Review of adequacy of the assessment of ecological and biodiversity issues undertaken for the Williamstown Quarry Project Environmental Impact Statement (SSD_6125).

Report for the *Williamstown Residents Action Group* with reference to matters of NSW and national environmental significance

By David C. Paull (BSc, MResSc, Dip. Hum.)

26 January 2016

Figure 3: Map in Appendix 8 showing 'Results of fauna surveys' (Koala locations are indicated by red squares).

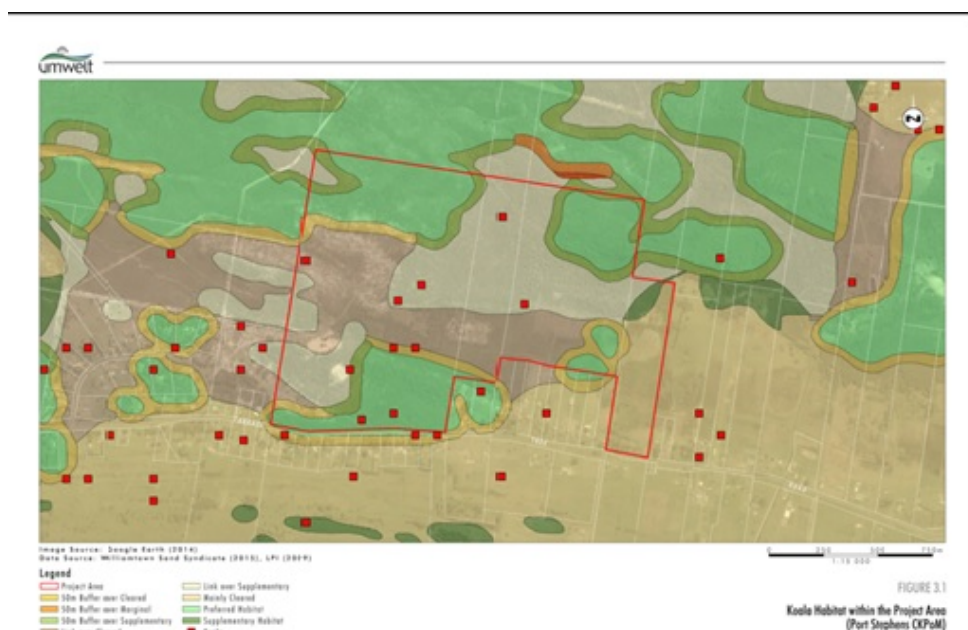
However the map of the results of the fauna surveys (Figure 4.4 in Appendix 8 - Figure 3 below) show the same ten locations as that already depicted in the desktop map. The results of the SAT assessments has not been indicated, indeed there is no information on the location or number of any Koalas provided by

Umwelt in Appendix 8 other than that already publically available. Whether this error is mistake or not, it is potentially misleading.

There are six historic records of Koalas within the development footprint, though where the consultants detected Koalas during surveys is not indicated. Umwelt have provided misleading information in that the figure which is supposed to show locations of Koalas detected in their surveys only shows the BioNet records. The number and location and age, sex or any information on Koalas detected during surveys is not provided.

*Figure 4. Map of study area and surrounds showing extent of predicted GDEs (Source GDE Atlas)*

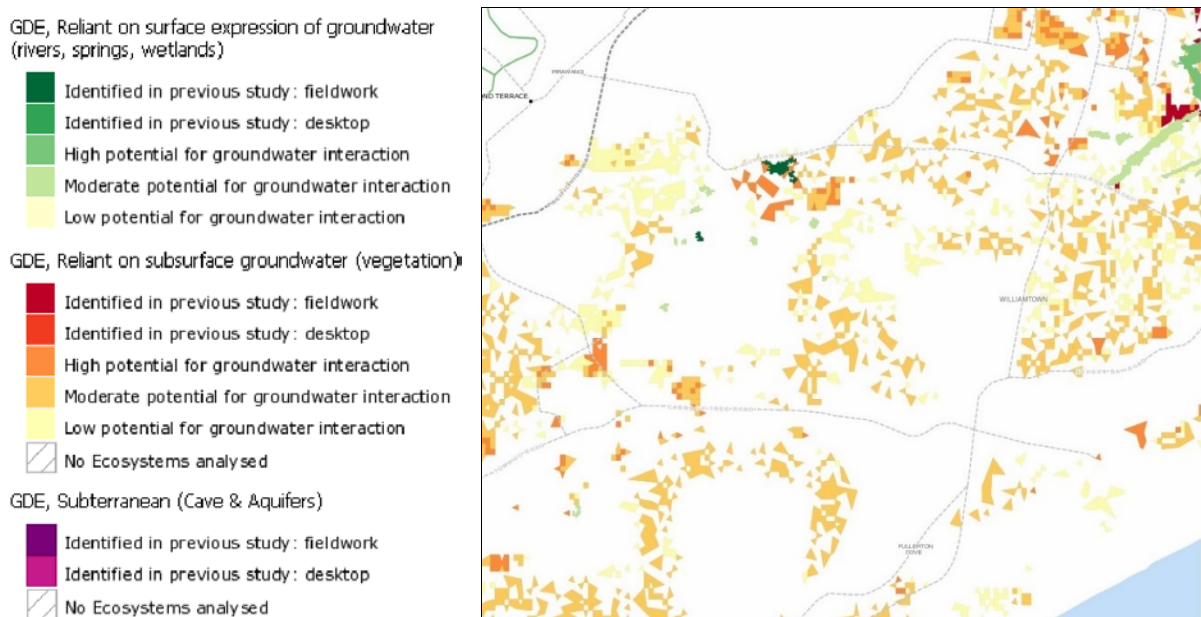
Sand crests such as that being proposed for sand mining generally lie well above the water table, but their landscape function is to act as zones of water recharge. How this development plan will affect levels of recharge into the surrouding environemnt as wel as natural flow patterns and resultant impats on GDEs (includingThreatened Ecological Communities) has not been addressed in the EIS.

While the area of Swamp Forest that will be removed may be small, this suggets that the development plan will be encroaching into a lower lying swamp area. If this is the case, then impacts of edge effects and reduced re-charge rates on neighbouring areas of GDE have not assessed either in the 7-PartTests or the GDE assessment.
